Application by AQUIND Ltd for the AQUIND Interconnector

The Examining Authority's further written questions

Compulsory Aquisition Hearing 1 – Appendix 1
- Exhibit 5 Drawing showing indicative
proposed haul road on the opposite side of
Day Lane

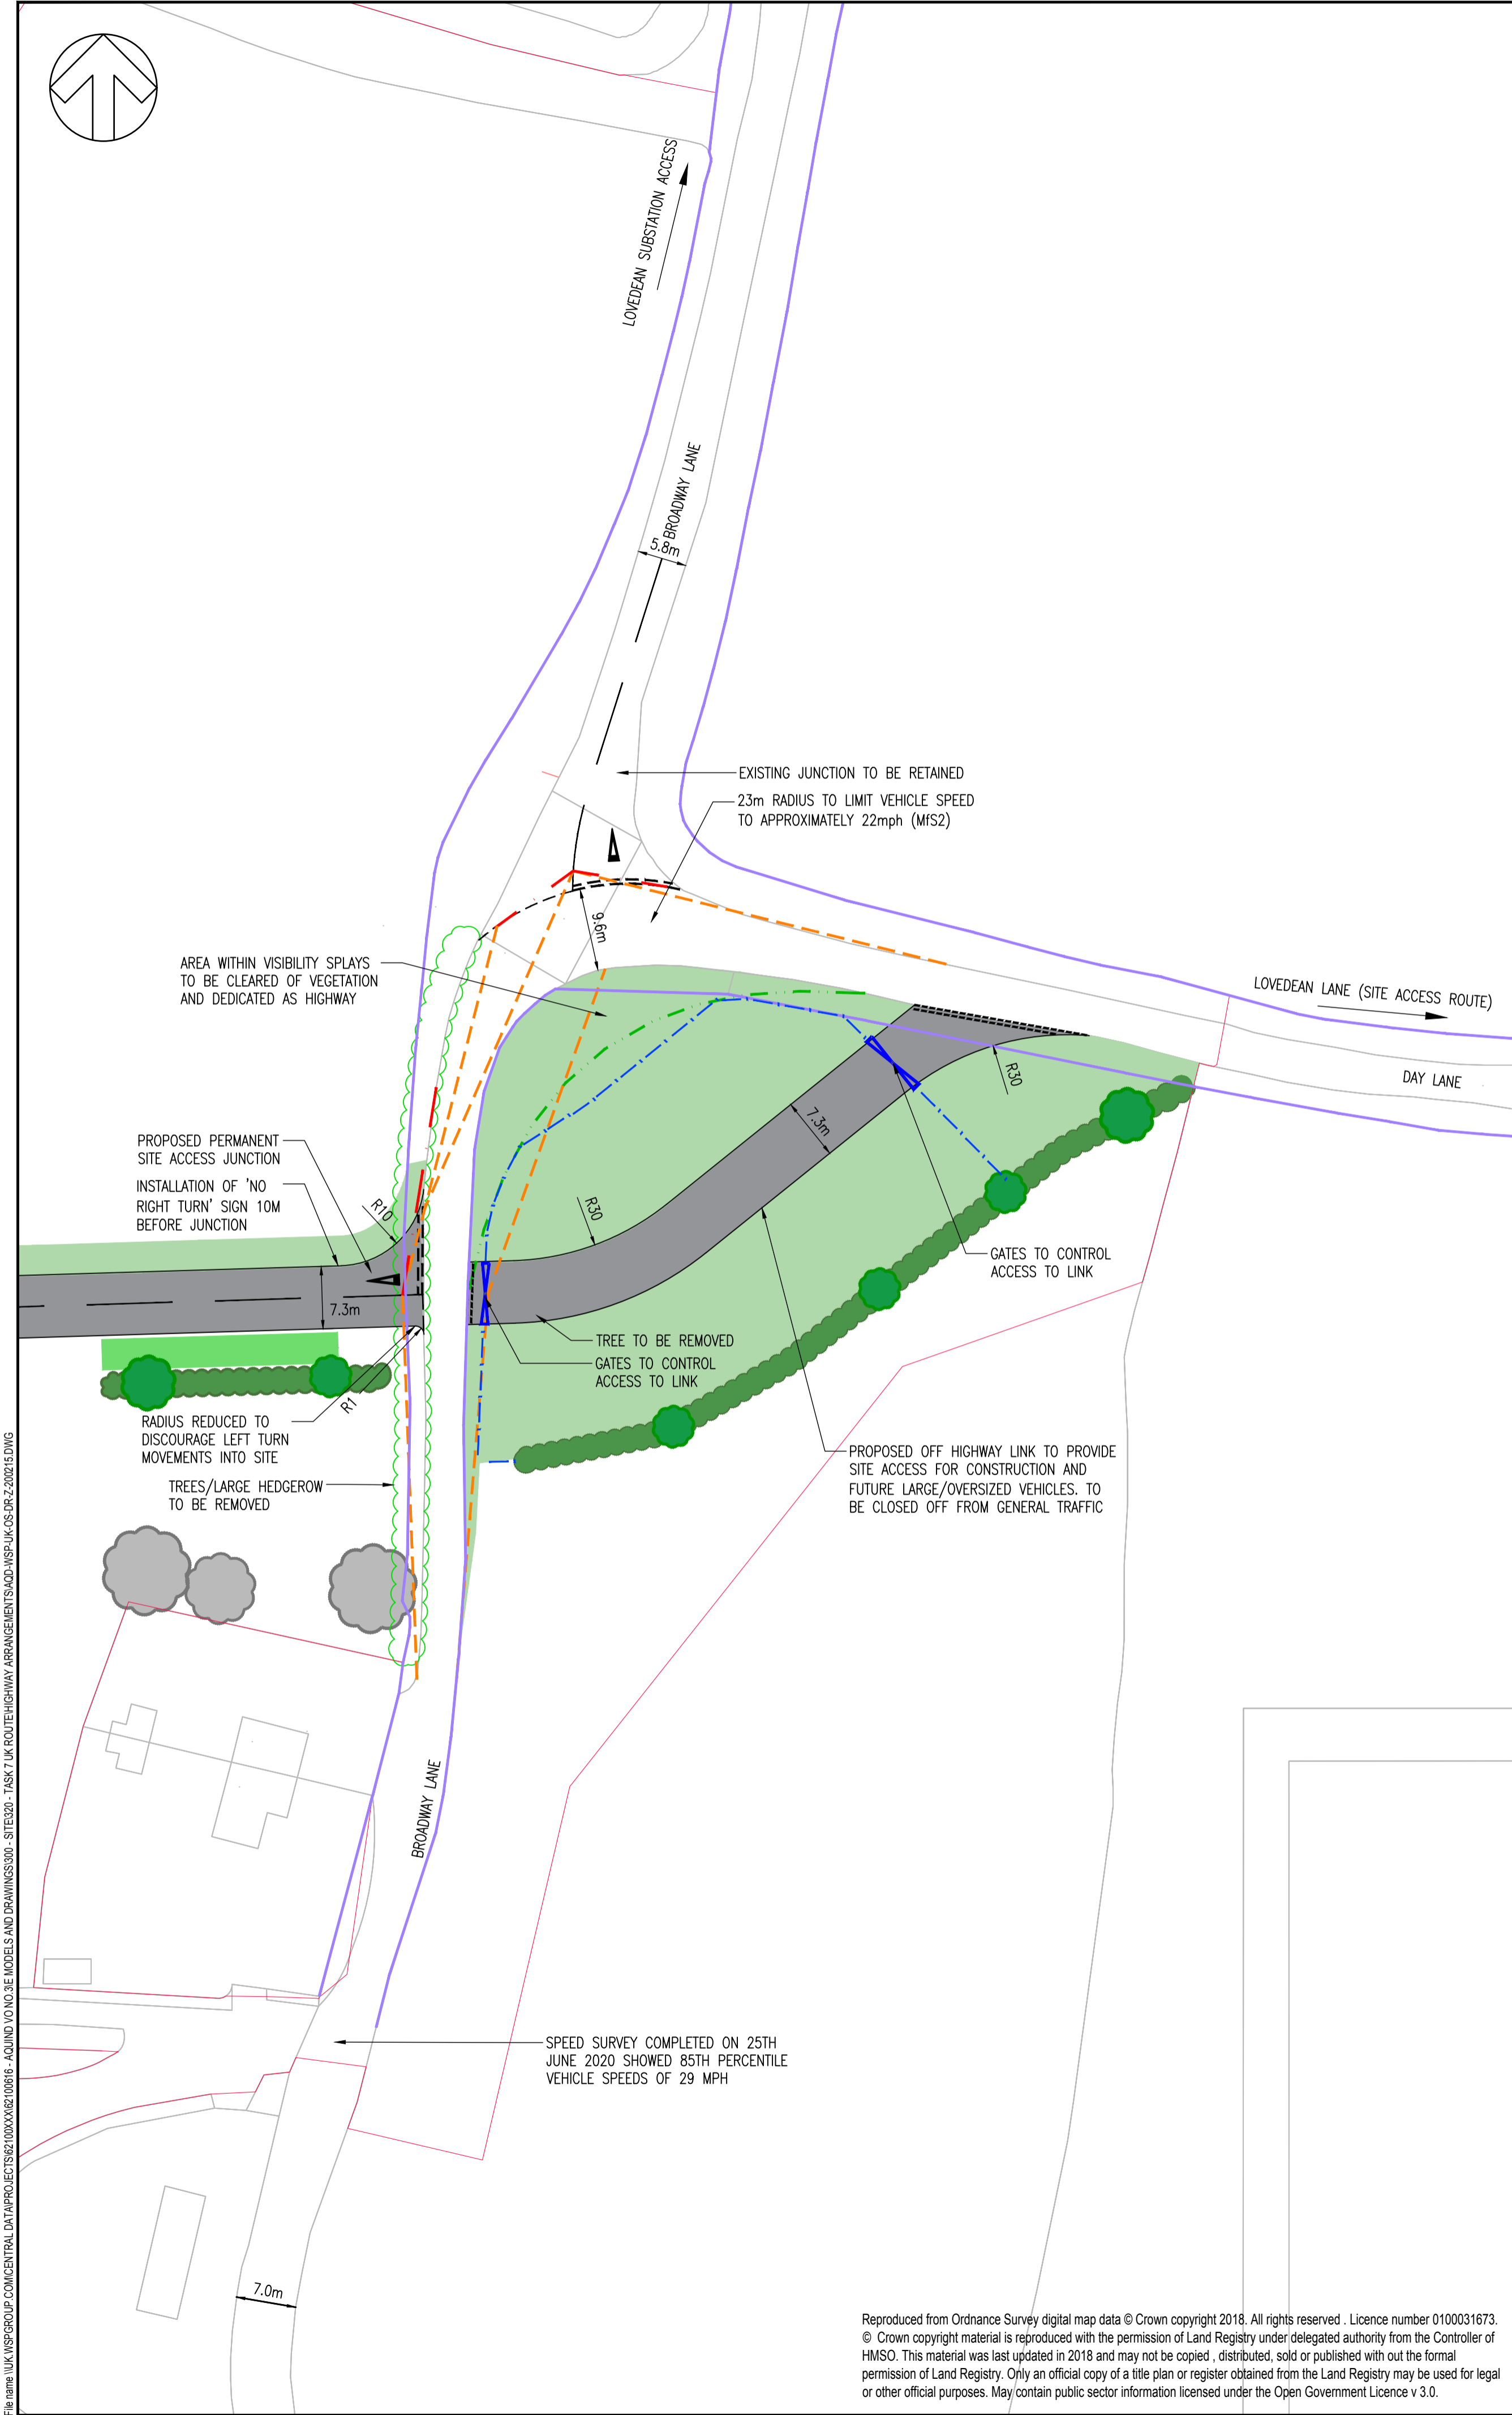
Reference	Respondent(s)	Question	
			update note. There remain a number of concerns about the impact of the proposed works on the operation of the bus routes.
TT2.16.5	Applicant	Hampshire County Council has suggested that the Applicant should monitor the proposed construction worker shuttle bus services to check the provisions are fit for purpose. How does the applicant intend to ensure that the provisions are fit for purpose and how are they secured through the dDCO?	The Highway Authority note that no amendments have been made to the Travel Plan within the Applicant's deadline 6 submission to address this matter. HCC have subsequently discussed this matter further with the Applicant. Further detail on HCC's position has been provided within its deadline 7 response.
TT2.16.7	Applicant	The Joint Bay Technical Note [REP6-070] shows indicative locations for joint bays. Whilst it is acknowledged these are indicative and there are more shown than is permissible in the dDCO, the ExA notes that JB's 11, 12, 13, 14, 15, 16, 18 and 19 in particular appear to be within the highway (where the definition of 'highway' incorporates the carriageway and footpath and cycle path margins). It says in APP-137 paragraph 22.4.7.15 that joint bay locations have been included, all of which provide adequate space for construction works to take place without blocking the carriageway. Can the Applicant therefore explain:	Hampshire County Council have made detailed comments on the proposed joint bay locations within its deadline 7 written response.

Reference	Respondent(s)	Question	
		<p>1) Whether the single-lane closures or shuttle-system for traffic would constitute traffic management for which there should be no more than 6 occurrences on the network at any one time?</p> <p>2) What arrangements would be in place for the diversion of pedestrians or cyclists during the 20-day joint bay construction period?</p> <p>3) Have measurements been carried out along the Order limits to confirm that sufficient room (either 40m x 5m in the case of a single bay or 40m x 12.5m in the case of a double bay as shown in [REP6-064]) exists at all potential joint bay locations to confirm that the joint bay will not be in the carriageway?</p>	
TT2.16.8	Applicant Hampshire County Council	<p>It is proposed to use four passing bays in Day Lane to allow construction-related HGVs to pass non-project traffic and non-related HGVs, and images have been provided showing the locations in the <i>Day Lane Technical Note</i> [REP6-073]. These passing bays appear to be beyond the Order limits and the document does not describe how the bays would be secured or surfaced. Would this be this through a s278 agreement?</p> <p>What evidence exists that all the land for the passing bays is within the public highway?</p> <p>What baseline evidence is there regarding the use, availability and environmental effects arising from the use of these parcels of land for passing bays?</p> <p>What surfacing would be used and how would this impact trees, hedgerows and wildlife?</p>	<p>HCC have reviewed the highway boundary along Day Lane as requested.</p> <p>Day Lane is a historic road which has been in existence from at least the 1840s (as being shown on the 1842 Catherington Tithe Map). It is therefore considered to be a highway maintainable at public expense in accordance with Section 36 (5) (a) of the Highways Act 1980 and S31 (1) of the same.</p> <p>The extent of Day Lane has been</p>
